Development Facilitation Team (DFT) – Review Comments

Project No: PR-2023-009591 Date: 12/06/2023 Agenda Item: #6 Zone Atlas Page: J-13

Location: [1224 BELLAMAH AVE NW between BELLAMAH and SAWMILL]

Application For: SD-2023-00214-PRELIMINARY/FINAL PLAT (DHO)

EXHIBIT
SITE PARKING

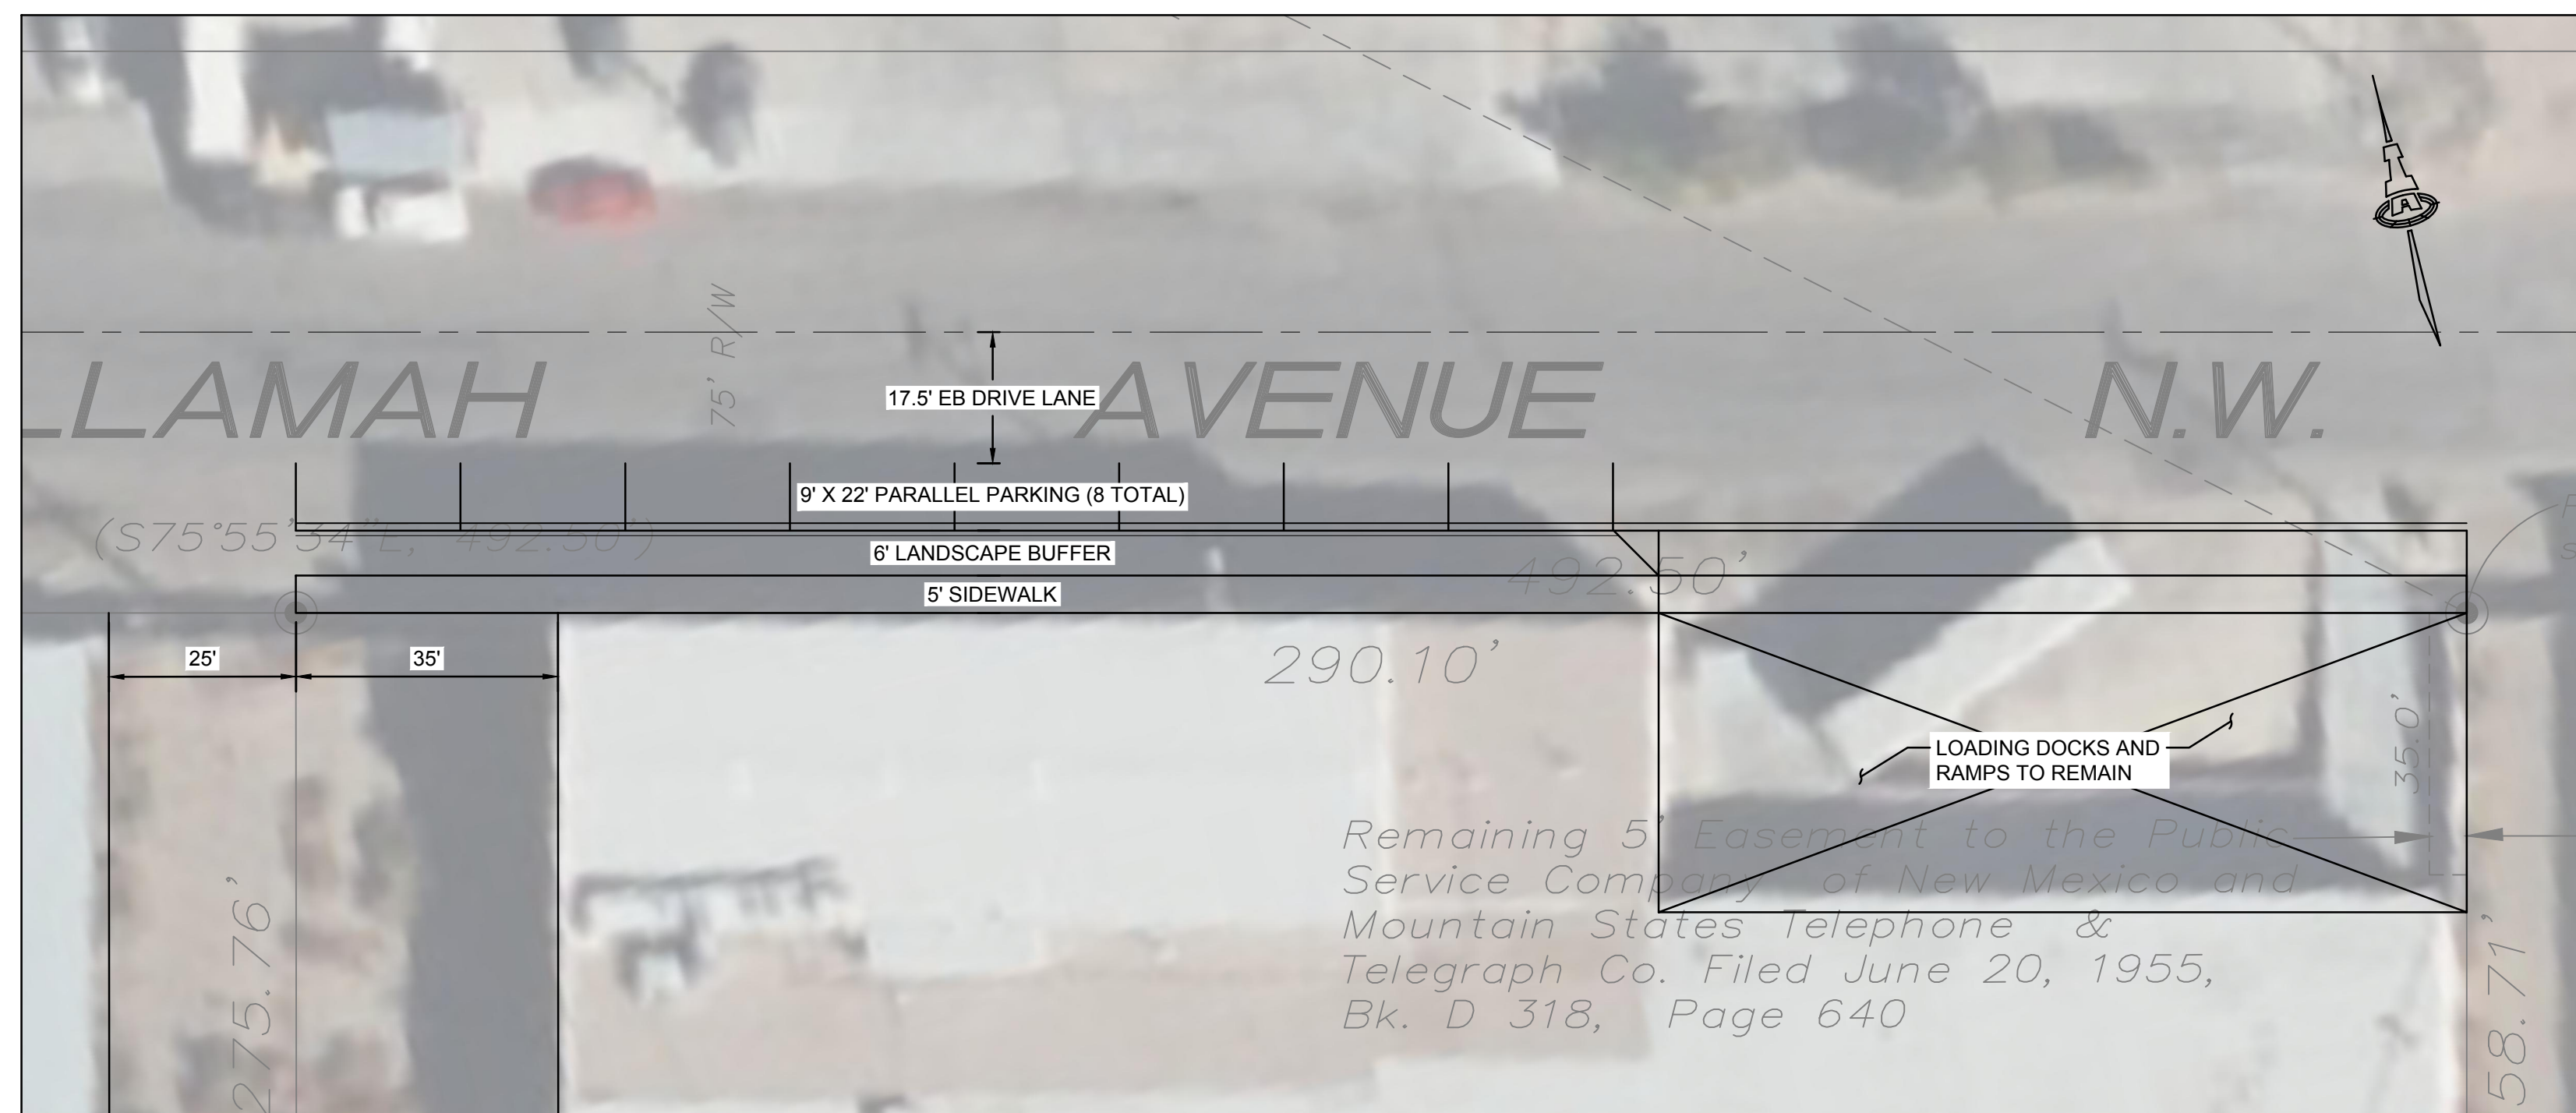
- Please confirm the proposed request is only to add a lot line to the existing development and that no new development would be taking place.
- Please confirm that the existing development would be meeting the required dimensional standards and not creating a nonconformity.
- Please clarify if parking calculations for the existing development are being affected by the replat and if a shared parking agreement will be needed.
